SPR EA1N & EA2 PROJECTS

DEADLINE 6 – POST HEARING SUBMISSIONS (ISH7)

BIODIVERSITY & HABITATS REGULATIONS ASSESSMENT

Interested Party: SASES

Works Nos. 19 and 20 - B1122 Aldringham Cable Corridor & R. Hundred Crossing EA1N/ EA2 Works Plan Onshore Sheet 5 of 12

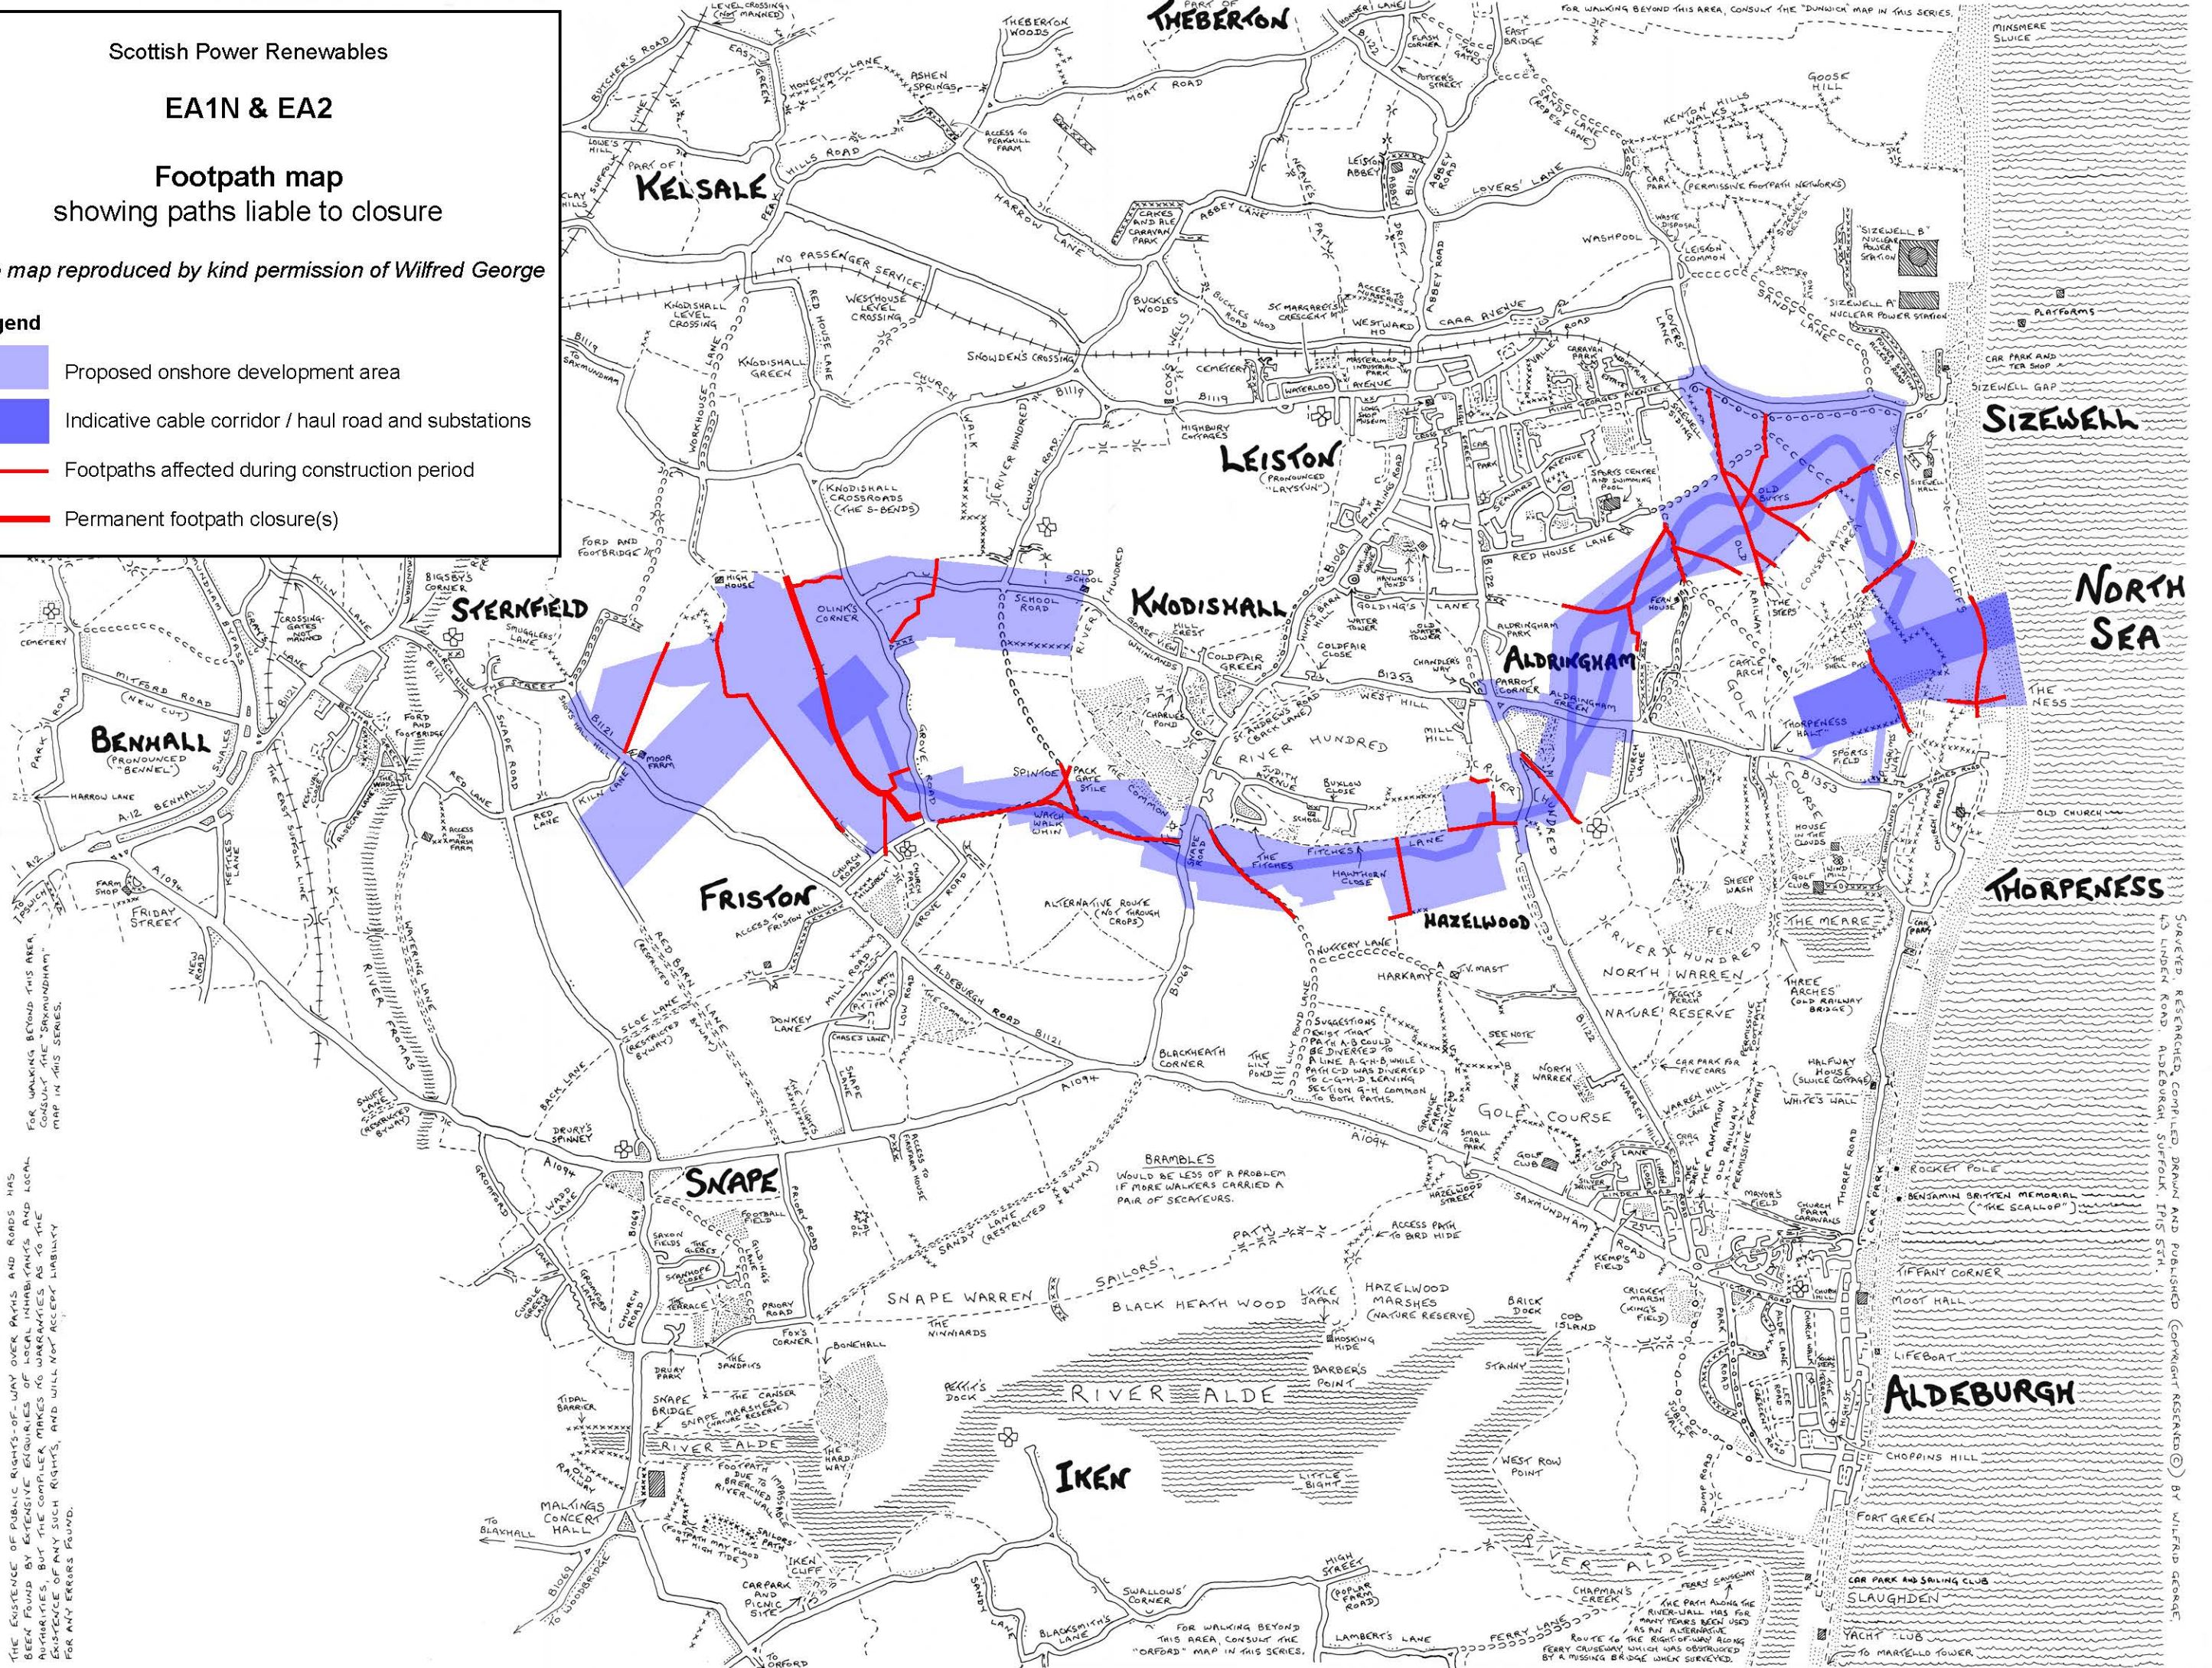
4. Prior to ISH 7 evidence was submitted by Gill Horrocks on 15th February 2021 regarding the existence of an [REDACTED]. Included in this document were a map and photographs of this sett. Works Plan Sheet 7a (REP3-006) is included below showing the relationship of the sett to the onshore substation site during the construction period. It can be seen that this is directly where the haul road enters the substation site and cannot be avoided.
